SUBJECT: SFD2403-0057
SINGLE FAMILY DWELLING

Here are the results of all Inspections located at **83 S ORANGE ST:**

Job	Truss	Truss Type	Qty	Ply	Lot 1 Jenkins Street
J0124-0187	A6	COMMON	3	1	160957483
					Job Reference (optional)

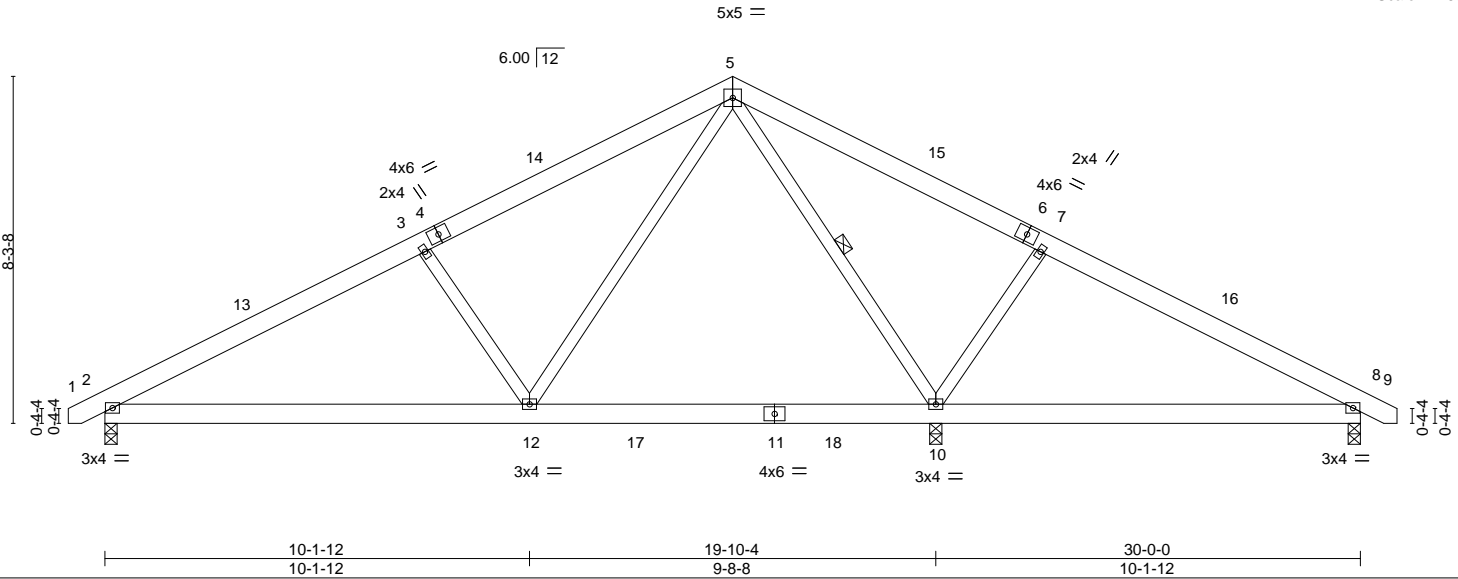
Inspection Type: ROUGH IN
Scheduled Date/Time: 4/11/2024
Completed Date/Time: 4/11/2024
Inspector: James T Hall
Result: DISAPPROVED
Remarks:
Notes: Missing nail guards on water lines at top plate over washer box
Replace notched stud at anchor bolt between windows in living room
Missing anchor bolt to left of window on right side wall in living room
Seal all holes in air barriers on front wall in living room
Missing anchor bolt to right of window on front wall in living room
Smoke detector needs to be at least 3 foot from return
Fasten toilet flanges per code
Need 3' head of water on drain line test
Fill Mike at drain pipe in spare bathroom
Missing nail guards on waterlines over master bath sinks
Missing nail guard on water line in back right corner of master bedroom
Missing roof truss bracing on A6 truss

Inspection Type: ROUGH IN REINSPECT
Scheduled Date/Time: 4/16/2024
Completed Date/Time: 4/16/2024
Inspector: Deen Taylor
Result: APPROVED
Remarks:
Notes:
